3 Selkirk Street | Informal Pre-Consultation Review | Site Plan Control Application | Riverain Developments Inc., main + main, NAK design strategies, RLA Architecture, J.L. Richards & Associates |

Panel Members in Attendance: David Leinster | James Parakh | Heather Rolleston | Colin Berman | Alex Taranu | Nigel Tai | Philip Evans |

1 SITE PLAN - PHASE 2 SCALE = 1:150

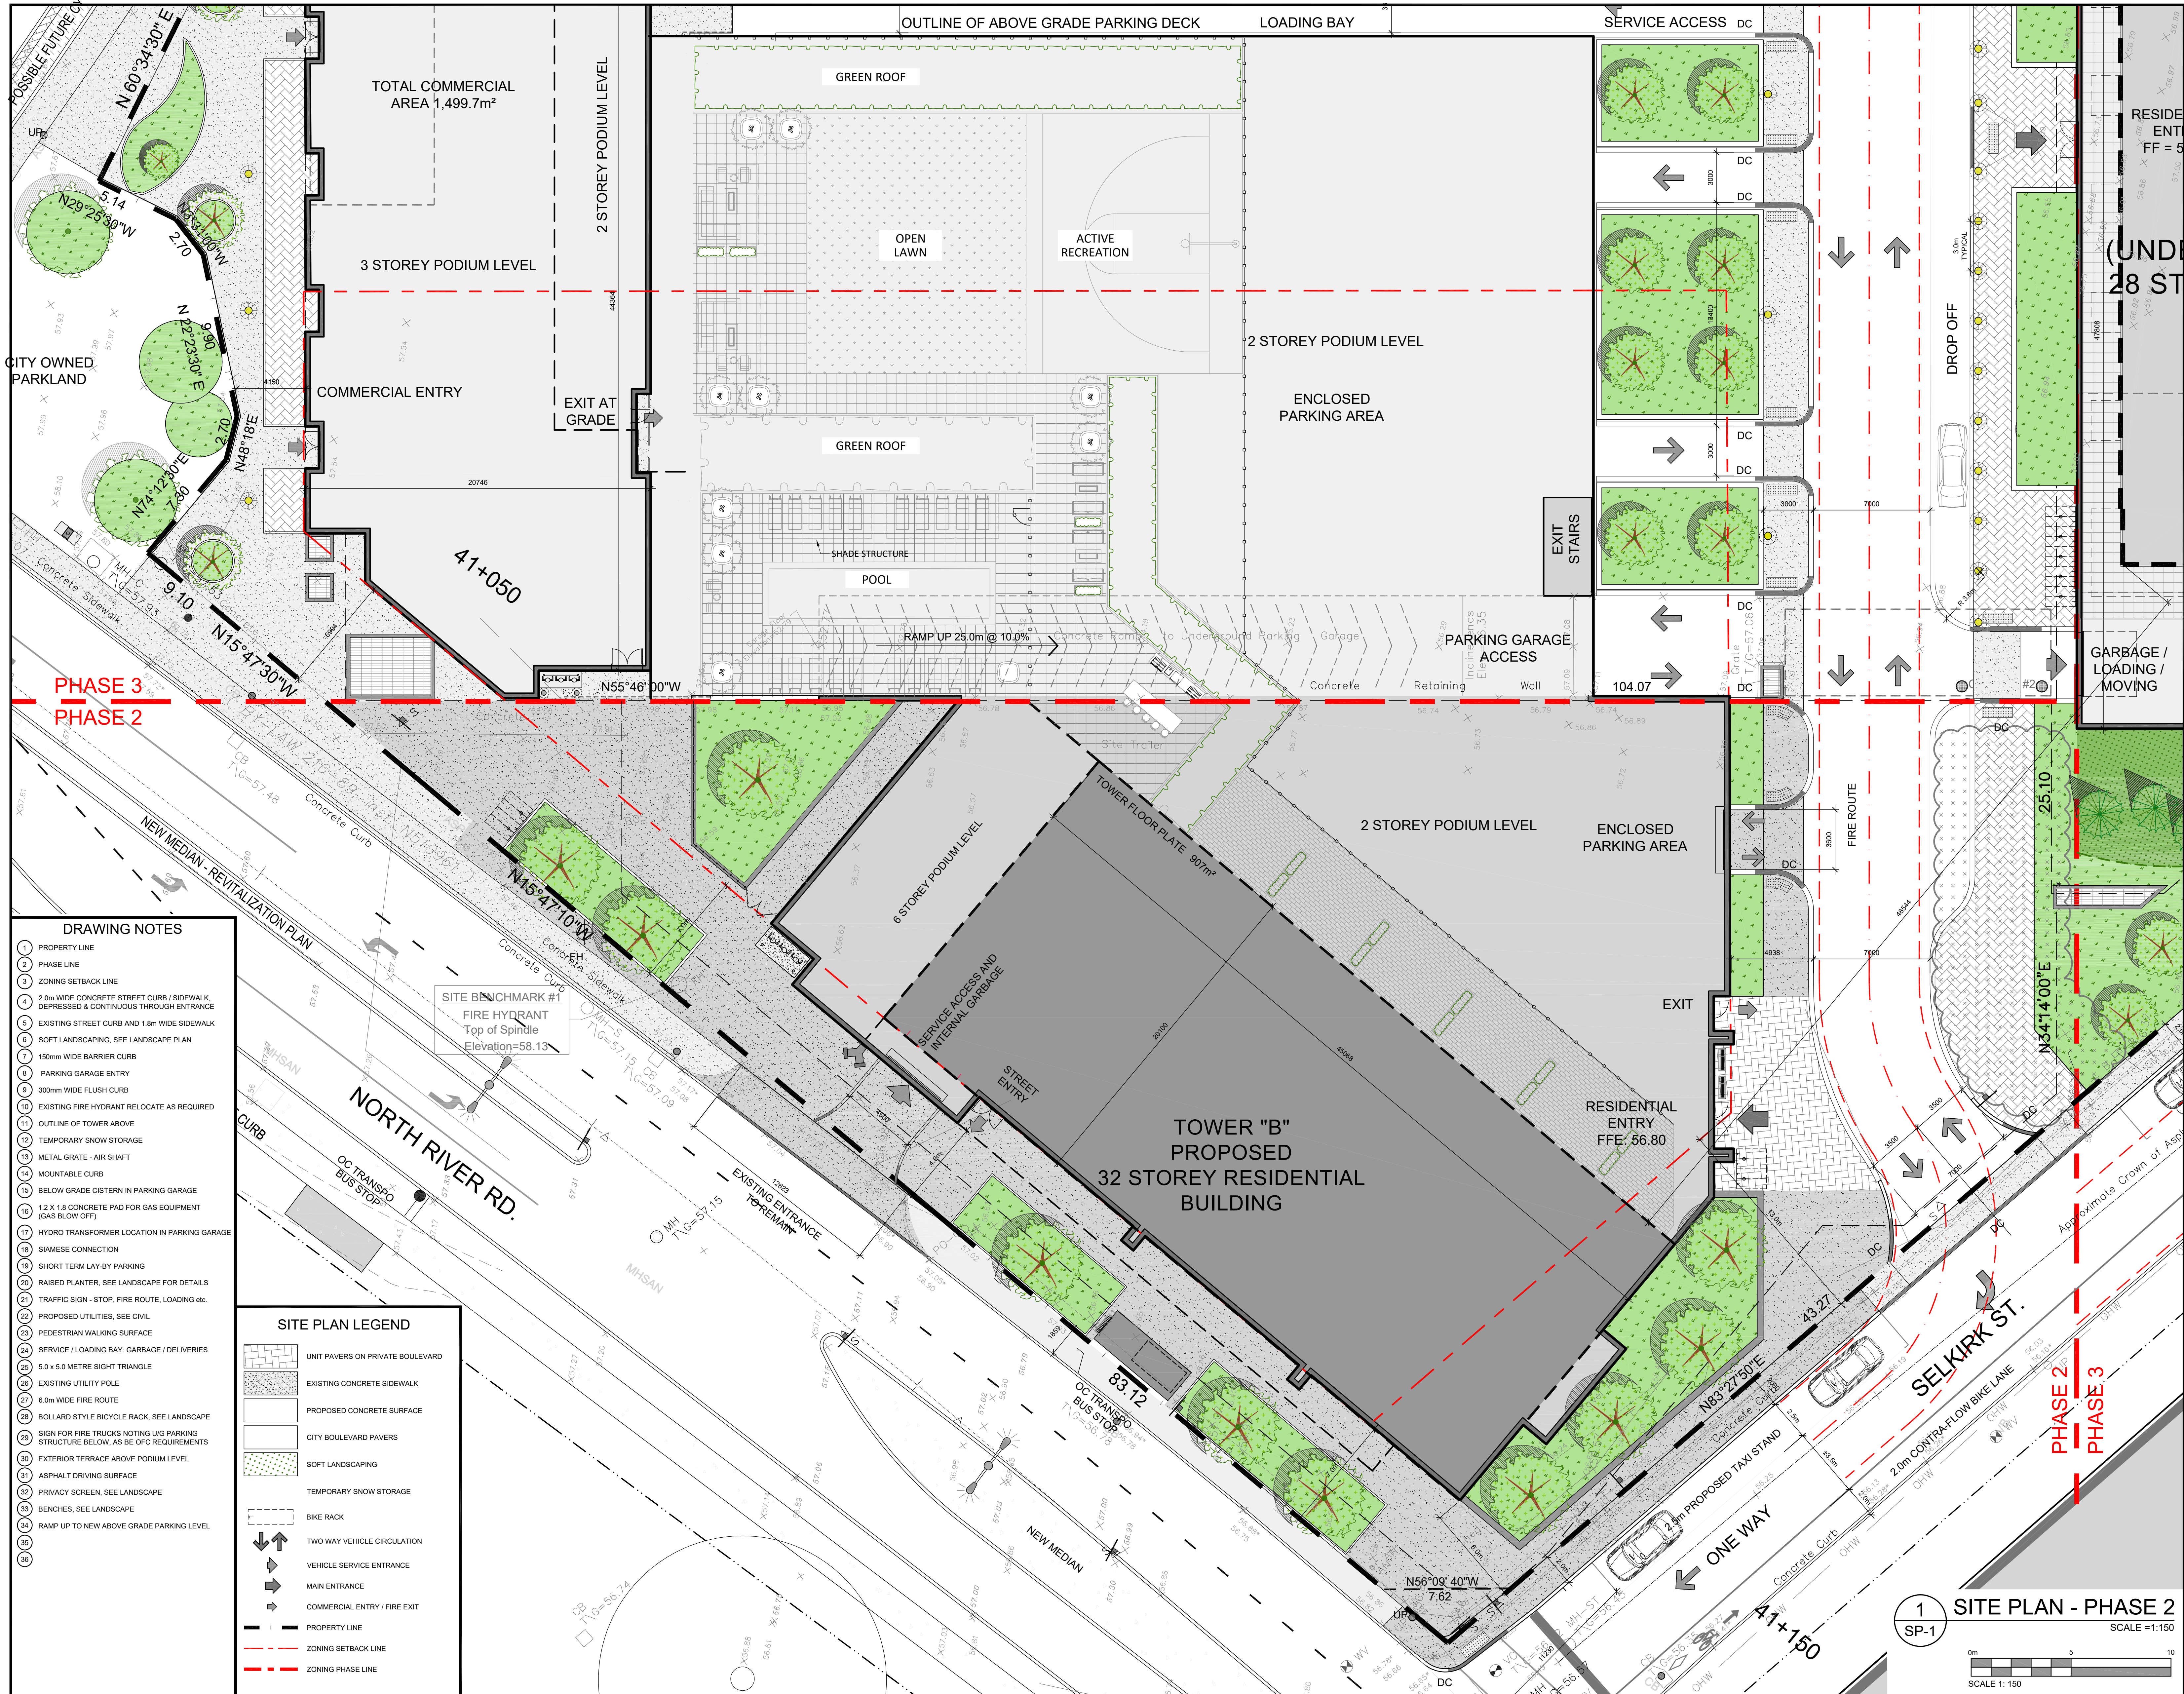
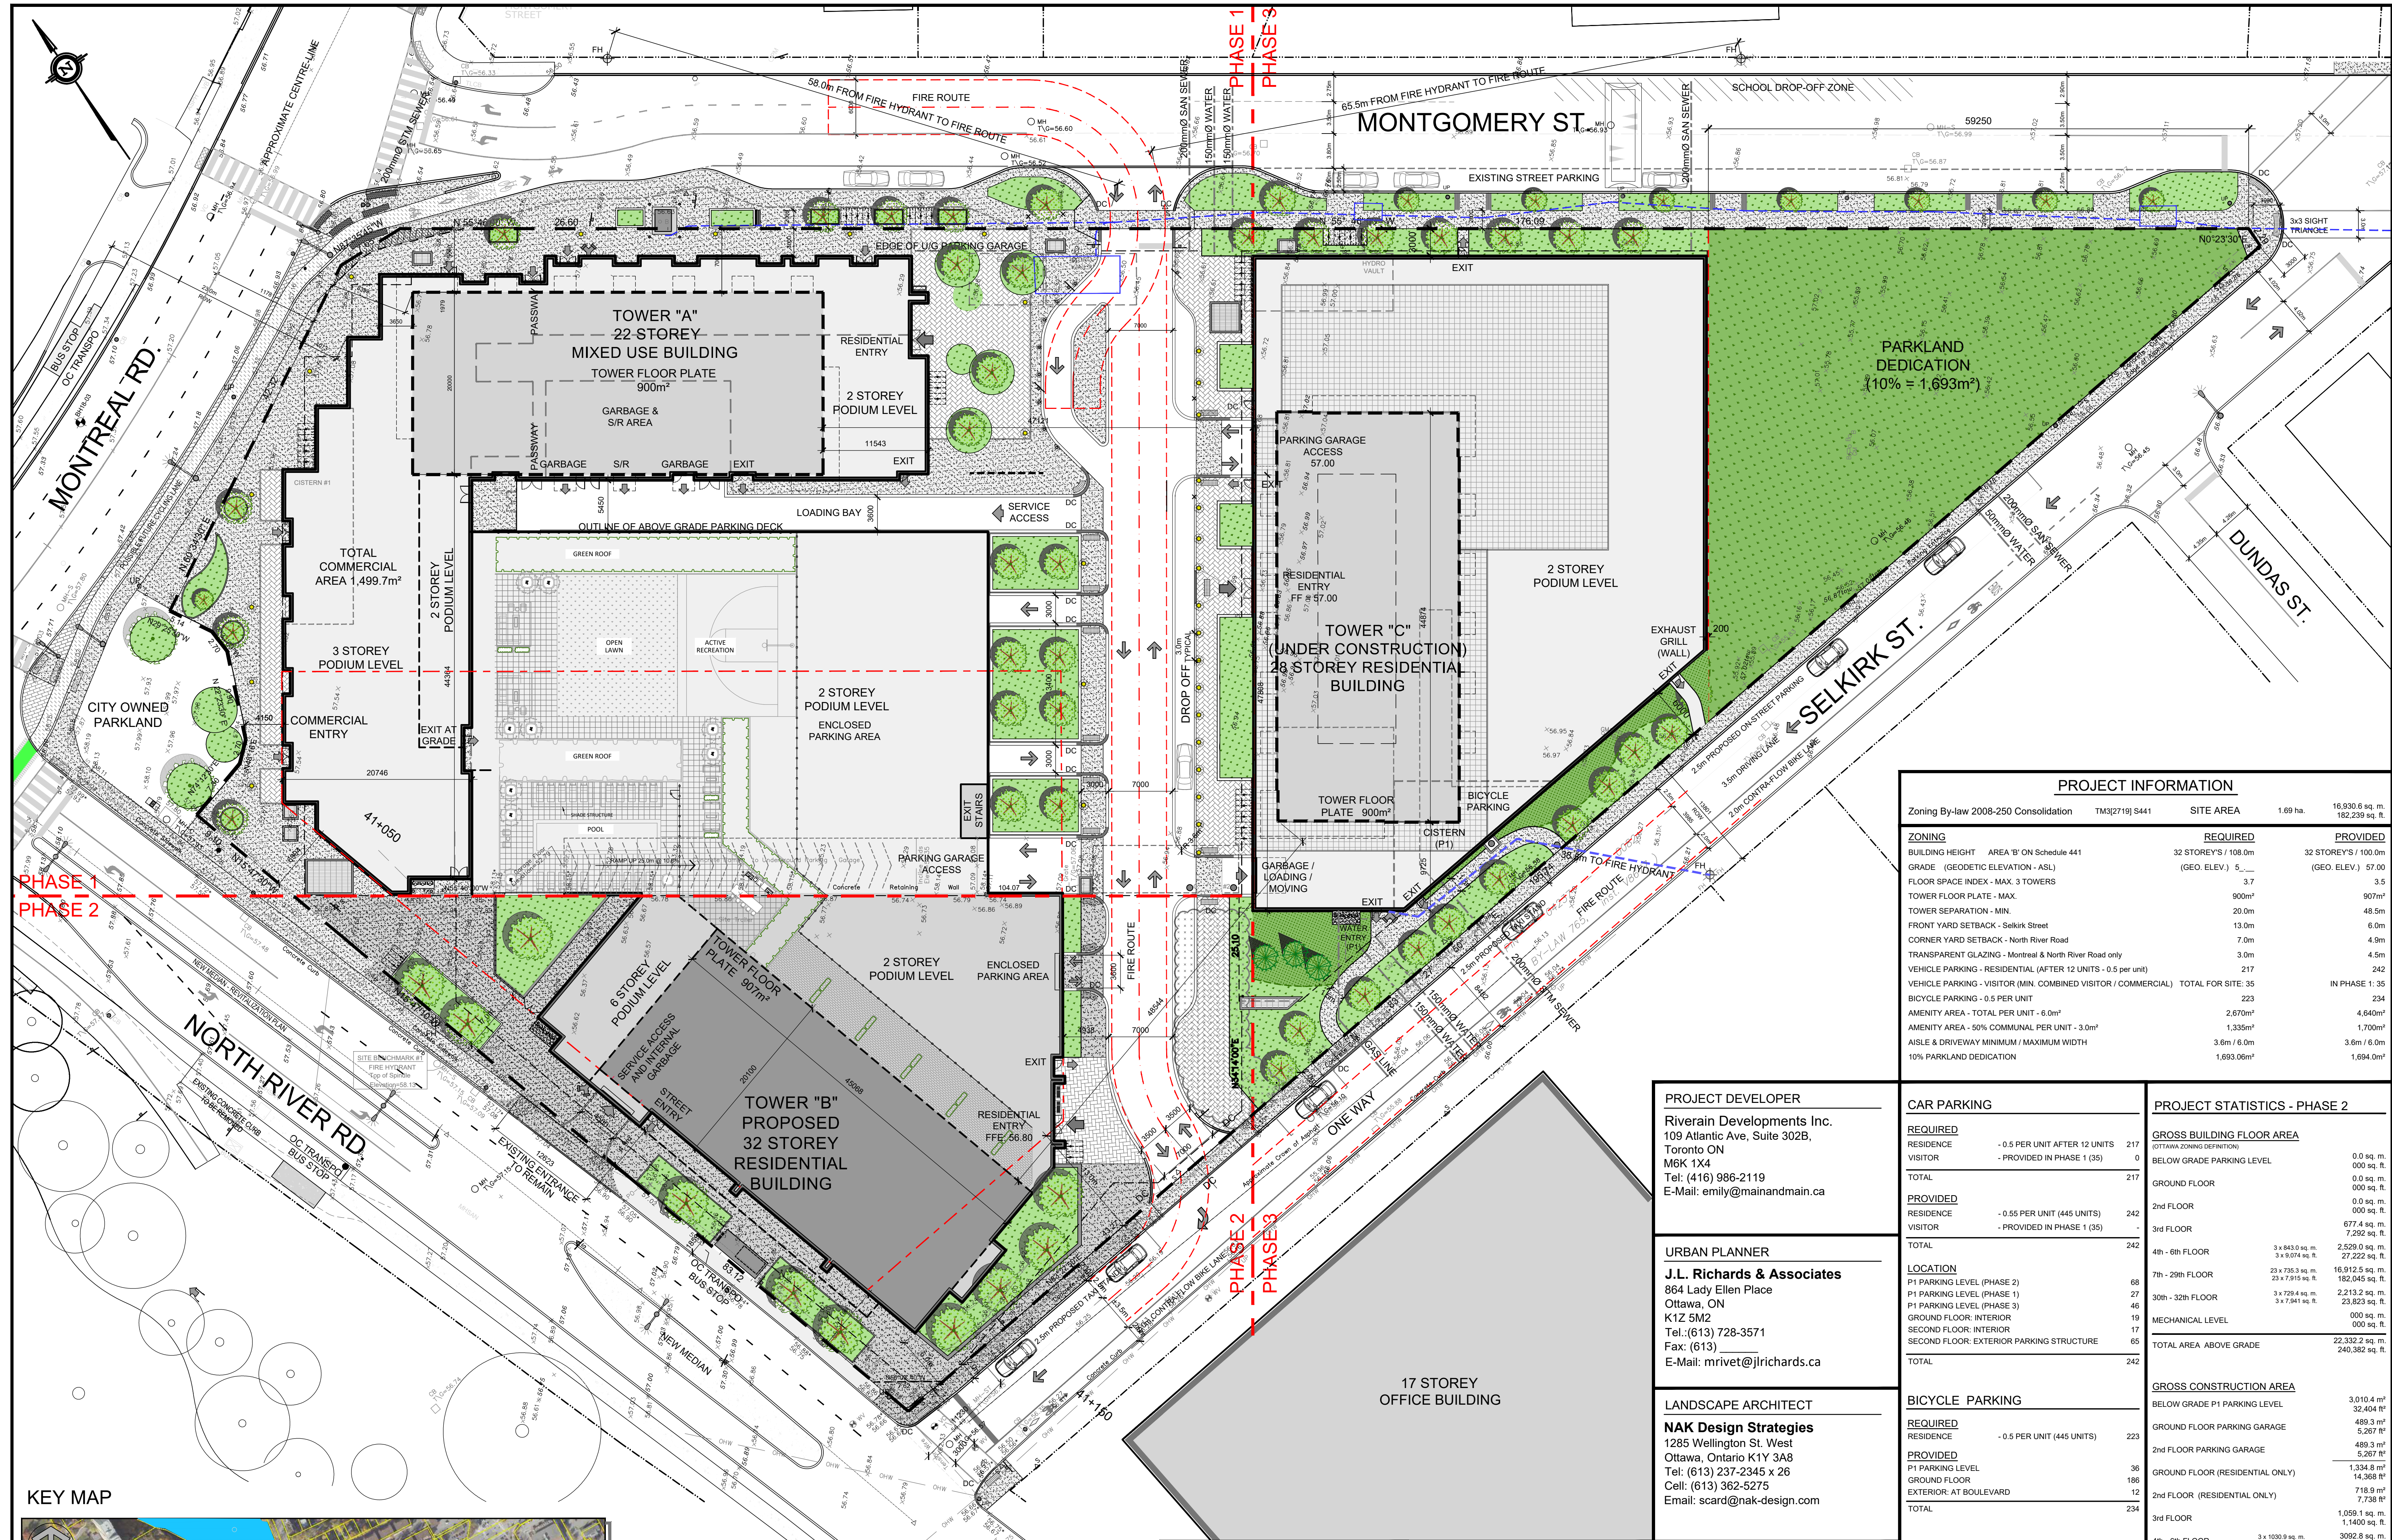
- The widened pedestrian zone along North River Road is supported and is seen as a positive improvement to the pedestrian experience.
 - The Panel raises concerns regarding vehicular access and servicing along North River Road and identifies the driveway and loading access as incongruent with the vision for this corridor.

- The Panel notes that the procession along North River Road is currently awkward due to the presence of garbage and loading functions and suggests that vehicular access be better internalized within the site.

- The Panel emphasizes the need for stronger animation and programming at grade and notes the absence of doors and active uses along North River Road, calling for improved activity and entrances.

- The corner of Selkirk and North River Road is identified as a key pedestrian condition. Large planters currently pinch the sidewalk, and the Panel encourages refinement to create a more open, generous, and welcoming corner.

- The Panel notes that the triangular space is consistently identified as a key public realm opportunity, with the potential to create an animated outdoor “living room” and emphasizes that the space should not be fenced.
 - The Panel suggests that this area could function as a social hub with community-oriented programming, while further exploration is encouraged.
- The Panel encourages a more resolved public realm strategy that prioritizes pedestrian comfort, reduces the visual and functional impact of servicing, activates key spaces, and reinforces the site’s role within the river corridor.
- The Panel emphasizes the importance of trees, greening, and shade to support comfort and livability and raises concerns regarding wind conditions and stressing the importance of early and thoughtful cycle-track integration.
